SSD-7538: Lots 7313, 7314, 7316, 7318 & 7319 DP 1185108 and Lots 3870, 3871 & 4143 DP 757298; Broken Hill North Mine, Broken Hill; Recommencement of Operations

Roads and Maritime Services

Following discussions with the Department of Planning and Environment (DPE), Roads and Maritime is not in a position to provide comments, and at this time, objects to the proposed haulage of ore using 30 metre road trains between North and South Mines. In objecting to the proposal, Roads and Maritime notes three outstanding issues that require further information and clarification:

Figure 2.12 presents the approved Potosi Mine transport route which permits transportation of ore via the following roads.

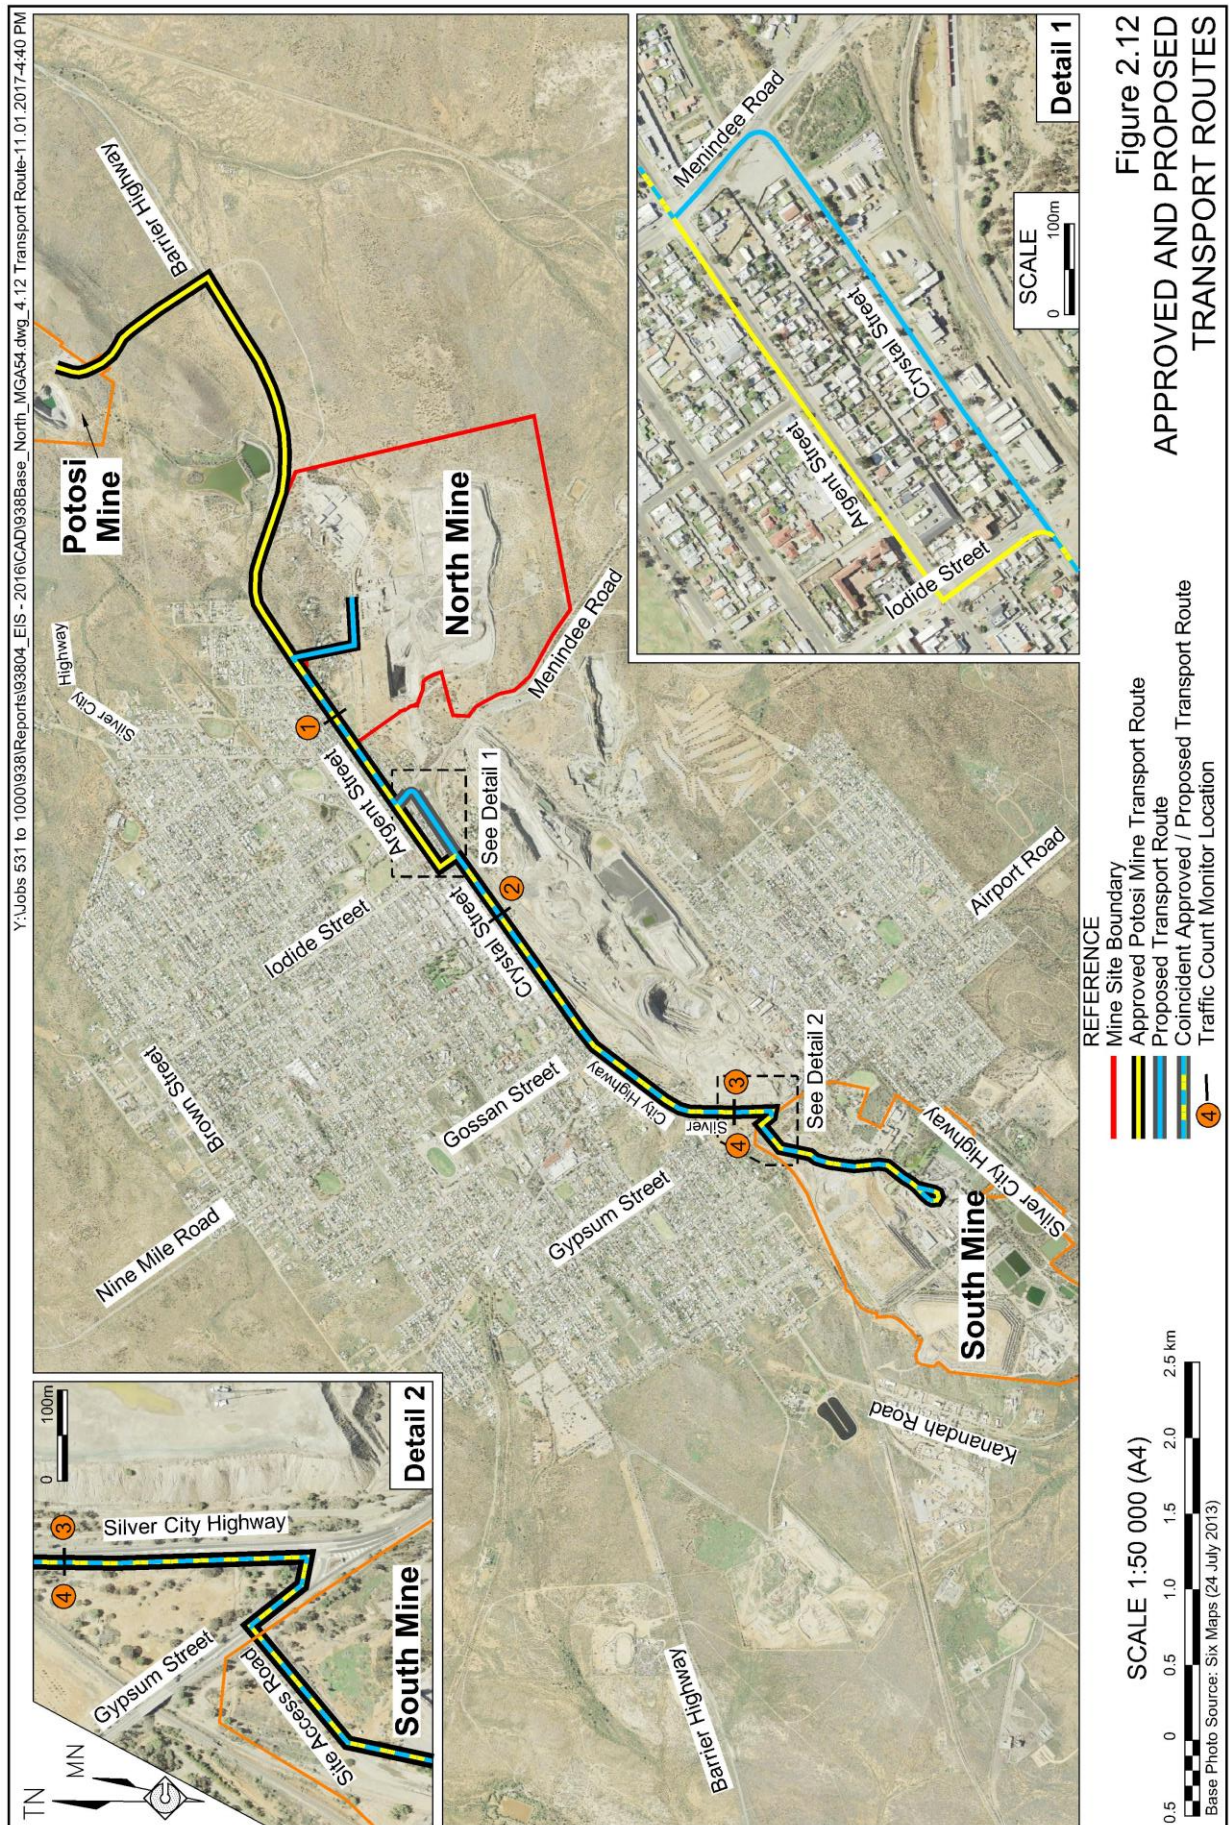
Roads and Maritime has received verbal advice that this route is now preferred by the applicant. It appears from the swept path analysis provided by the applicant that the use of this section of road in the haulage route would require widening of the Iodide and Crystal Streets intersection, relocation of an electricity pole, setback of a hold line at the Iodide/Argent intersection, loss of car parking in Iodide Street and road shoulder reconstruction. Roads and Maritime, at this time, is not satisfied that 30 metre road trains will be able to safely pass each other through this section of the road network.

Please note that 30 metre road trains are Restricted Access Vehicles (RAVs) and this section of road is currently open to RAVs up to 36.5 metres in length. At the time this part of the network was gazetted to permit 36.5 metre vehicle access, the road environment was assessed, including geometry and traffic volumes. An increase in length and/or volumes of vehicles using this route would change the environment. Should such change be assessed as adversely impacting road safety, the gazettal may be revoked or modified. It is important to be aware that the ability for RAVs to operate on this route should not be assumed and that improvements may be necessary to ameliorate an increased road safety risk, particularly that of conflict between RAV's and other vehicles.

1. Advice from DPE as to whether some or the entire haulage task can occur on rail.
2. Should the response in relation to (1) be no, clarification of the current approved haulage route.
3. Submission of a road safety audit for the proposed haulage route. The audit is to be prepared by a level 3 recognised road safety auditor and include template reviews of all intersections along the route.
